CITY OF ALBUQUERQUE

November 3, 2017

Re: La Hacienda Phase II Building
1925 Old Town Rd. NW
Traffic Circulation Layout
Architect's Stamp 10-24-17 (J13D037)

PLAZA HACIENDA ADDITION AT OLD TOWN  
PHASE II NEW SITE/LANDSCAPE PLAN  
1925 OLD TOWN ROAD NW, ALBUQUERQUE, NM  
PROJECT #1732

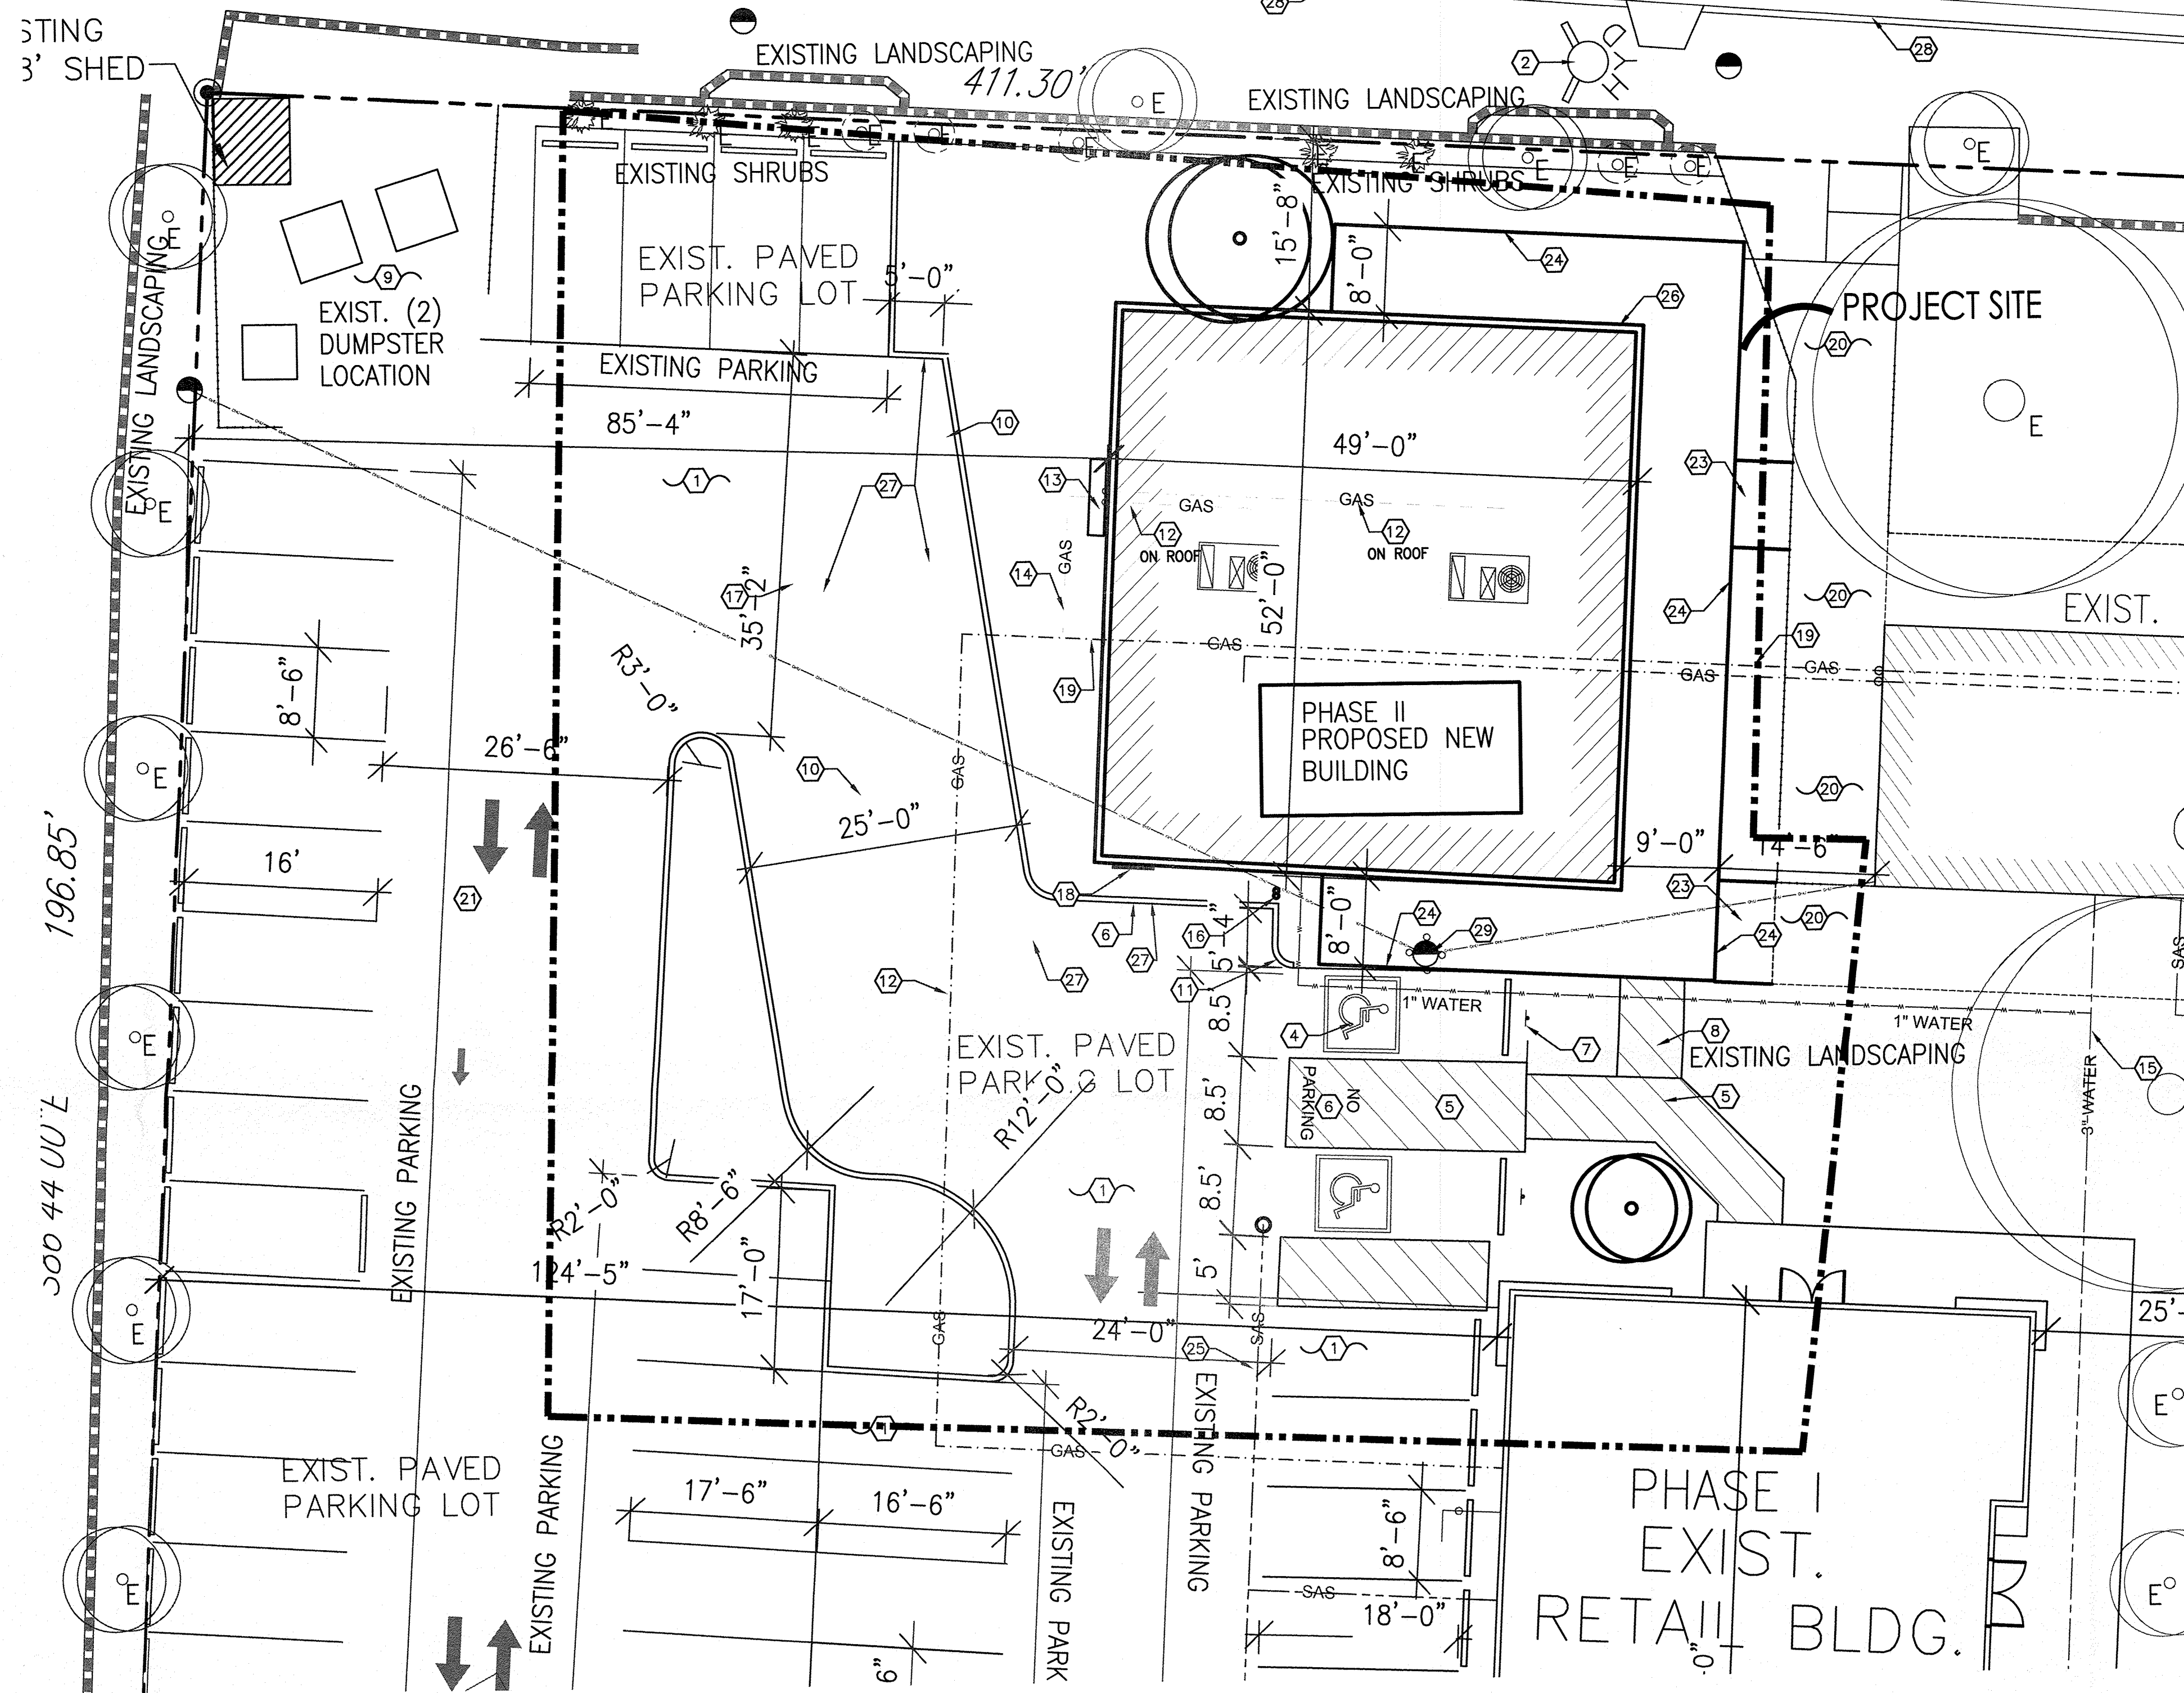
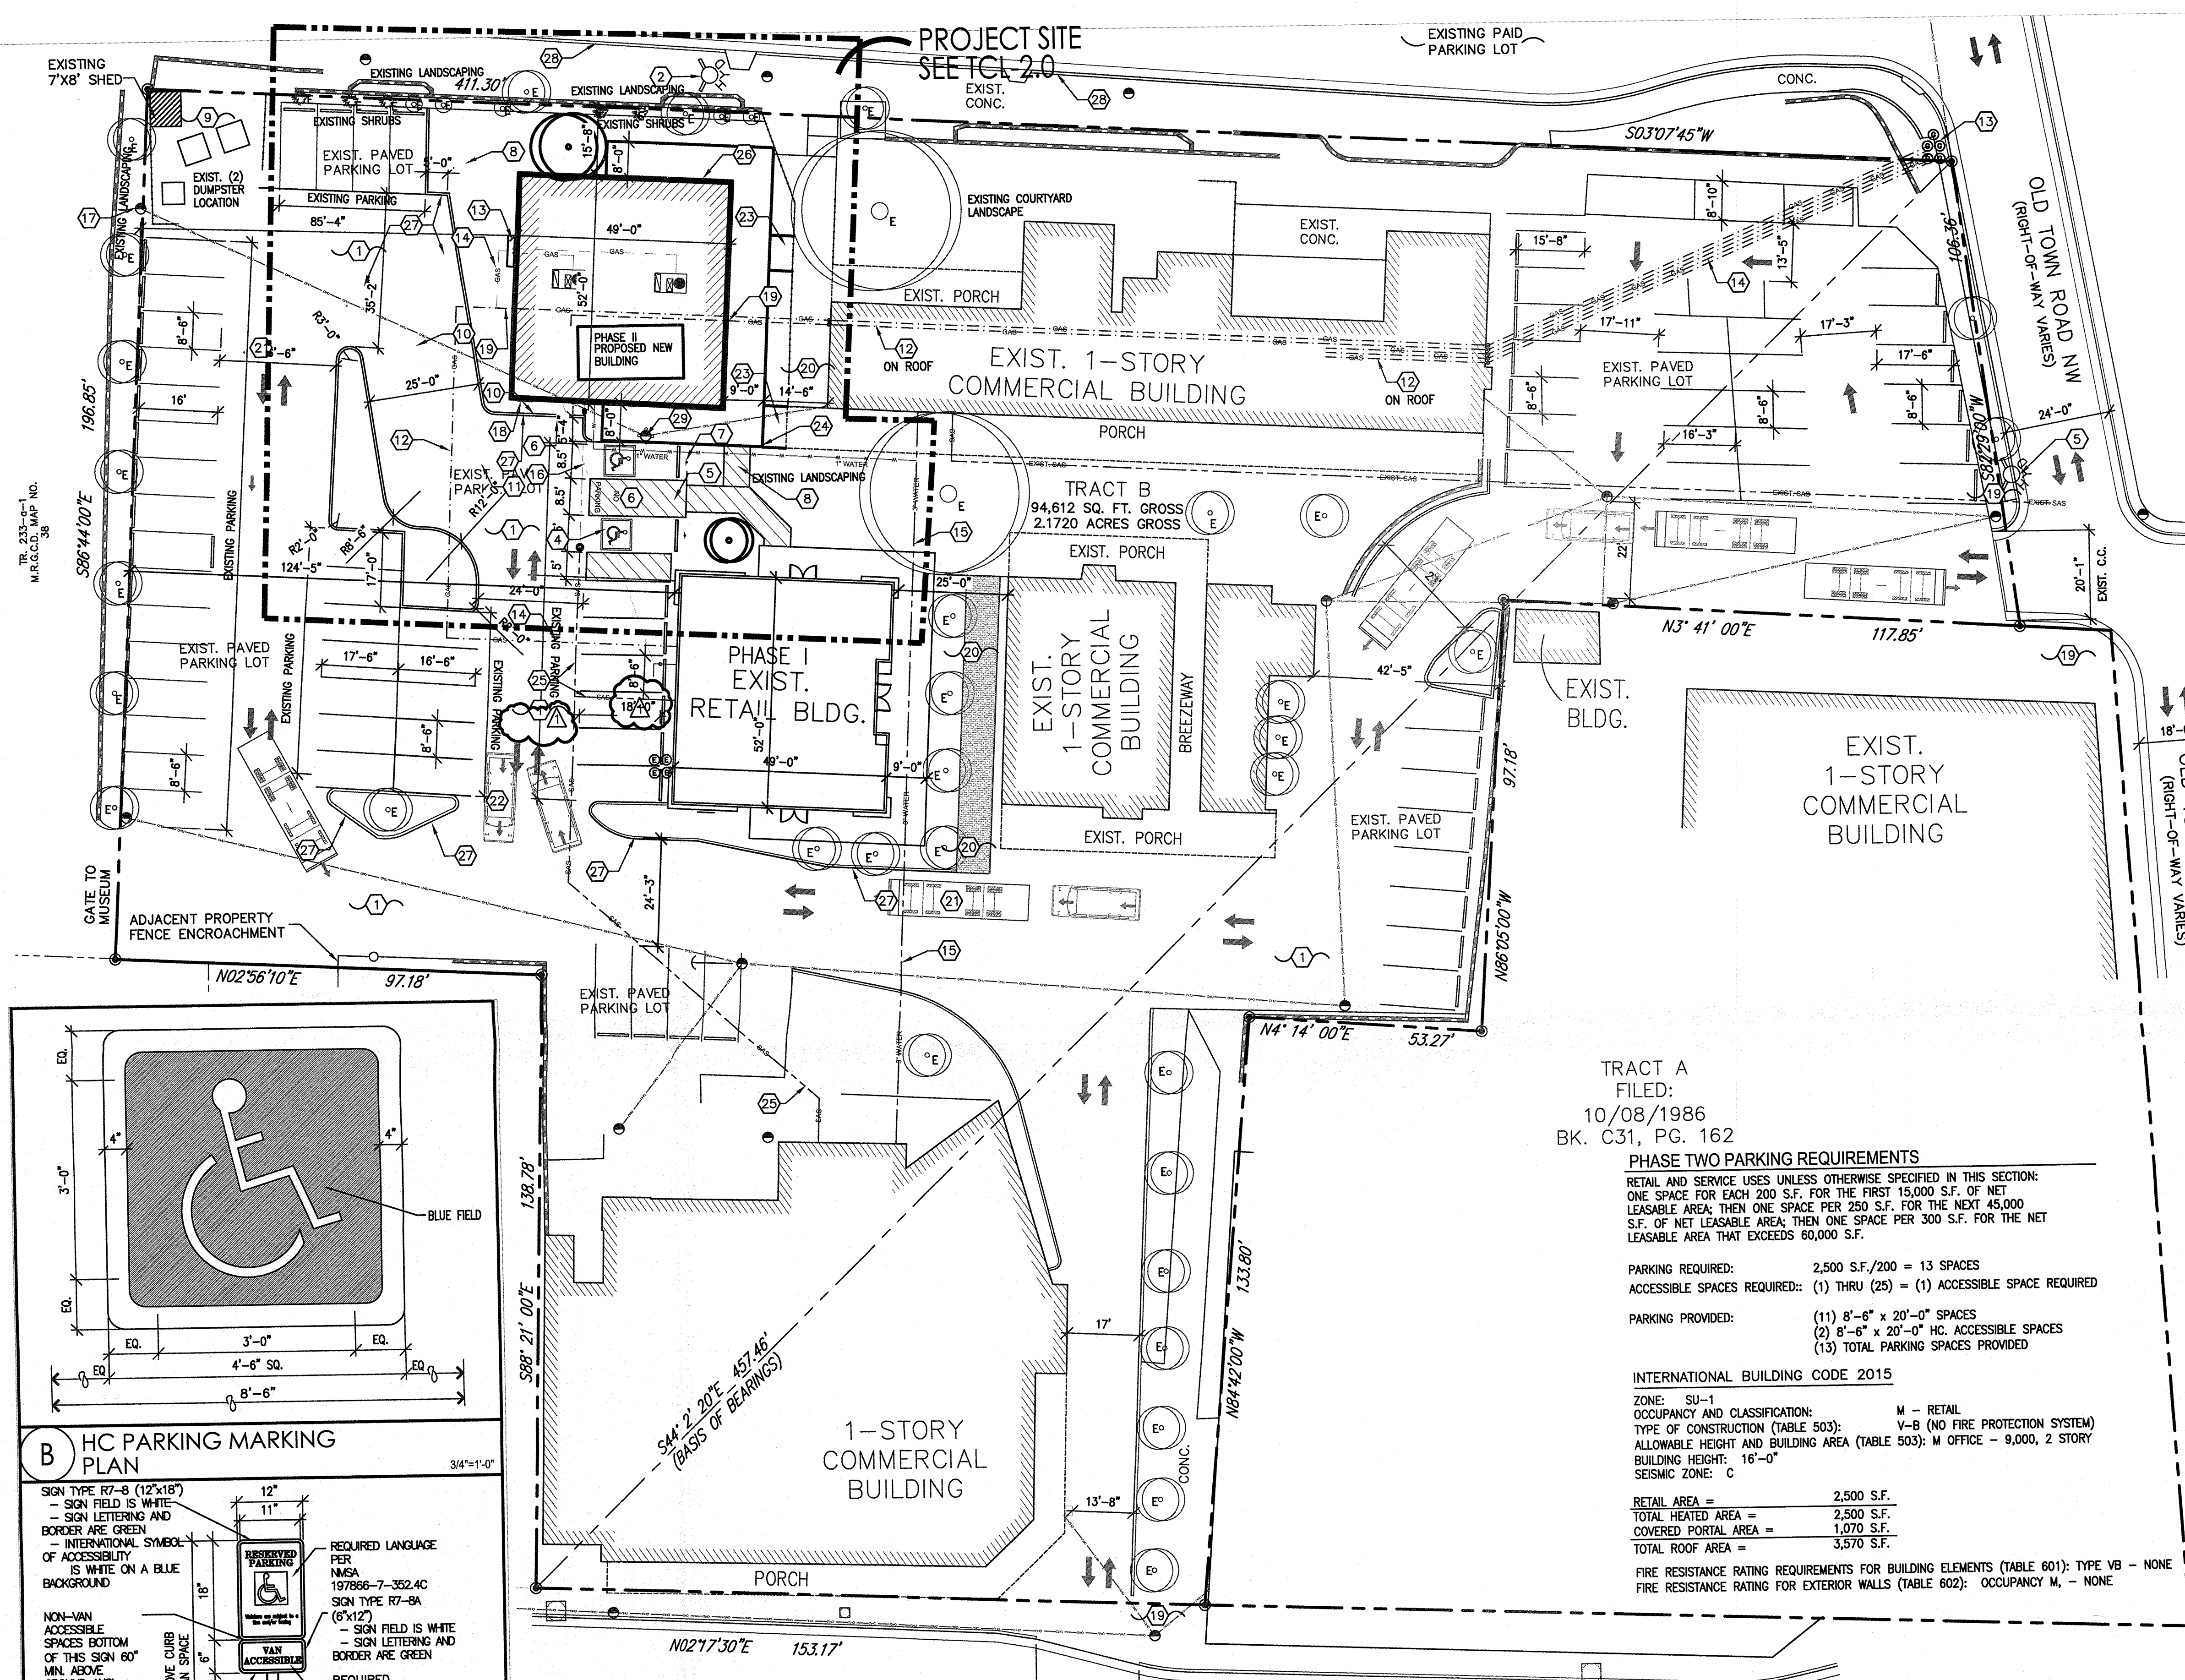
1. Per DPM, a 6 ft. wide ADA accessible pedestrian pathway is required from the HC parking stall access aisles to the building entrances. Please clearly show this pathway and provide details.
2. Please provide separate detail for the new phase of the development. The TCL is too cluttered to see what is being proposed.
